Les Gruen

Cactus Creek Ranch Variance of Use - Letter of Intent

# CACTUS CREEK RANCH

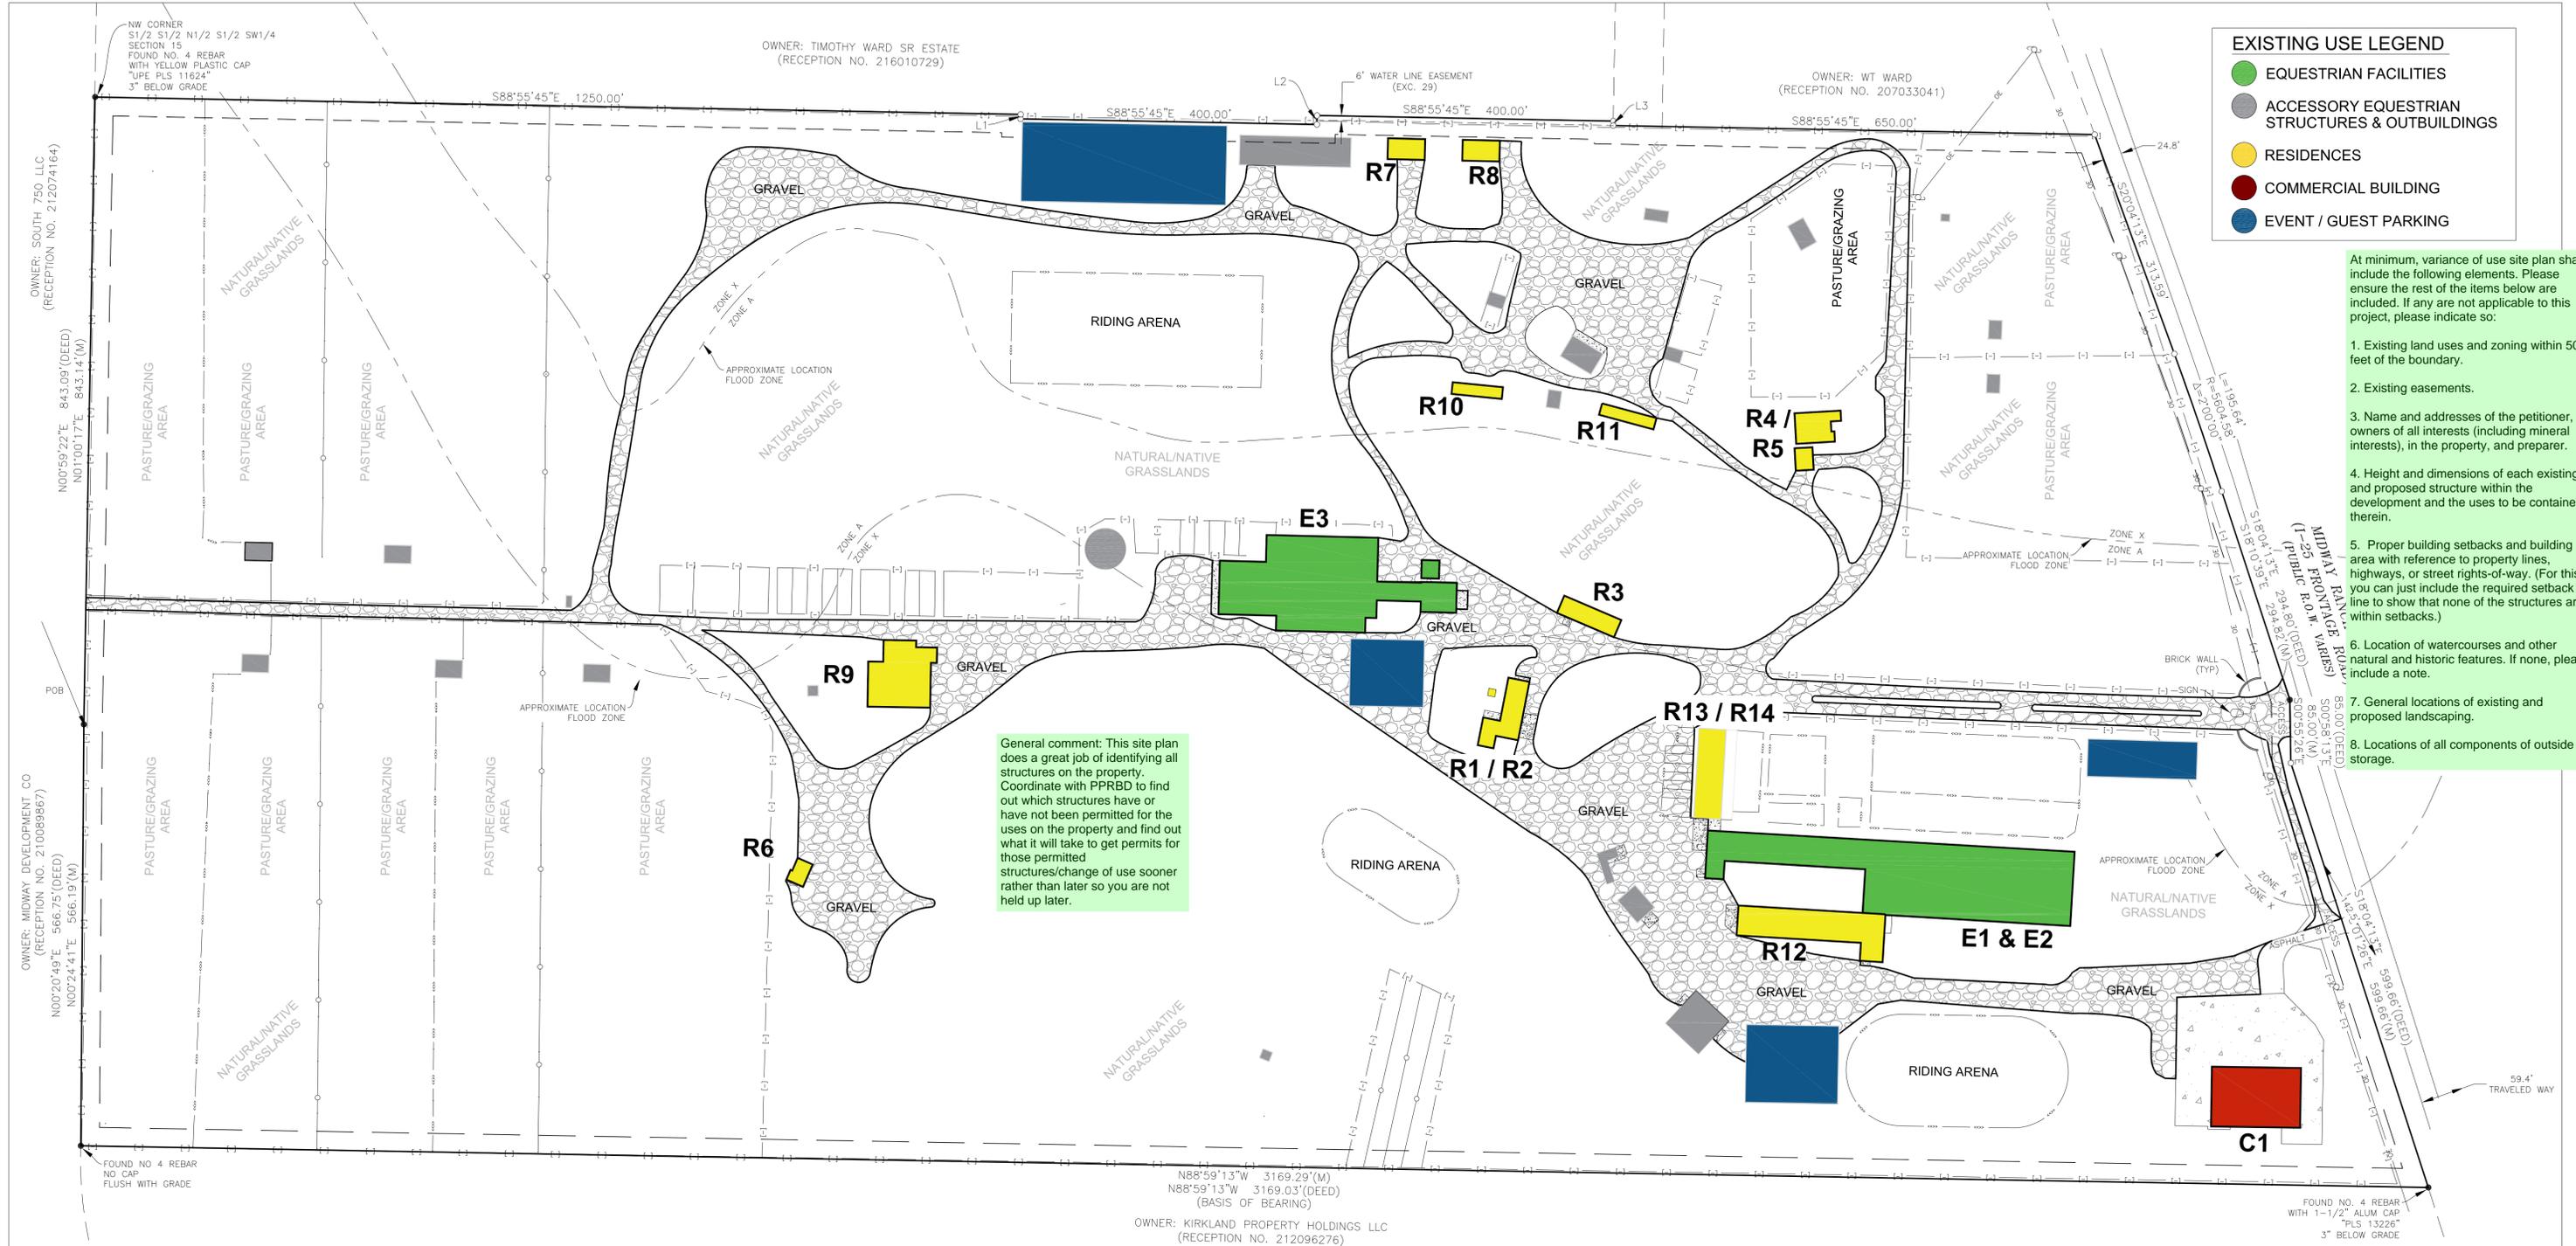
Parking areas on the plan do not indicate number of spaces. Please review the parking restrictions in Sec. 6.2.5 of the LDC and ensure that all uses on the site that have been discussed in this letter have adequate parking facilities.

No landscaping or screening measures have been provided for this site. At a minimum, the commercial uses should be screened from residential uses on and off the property.
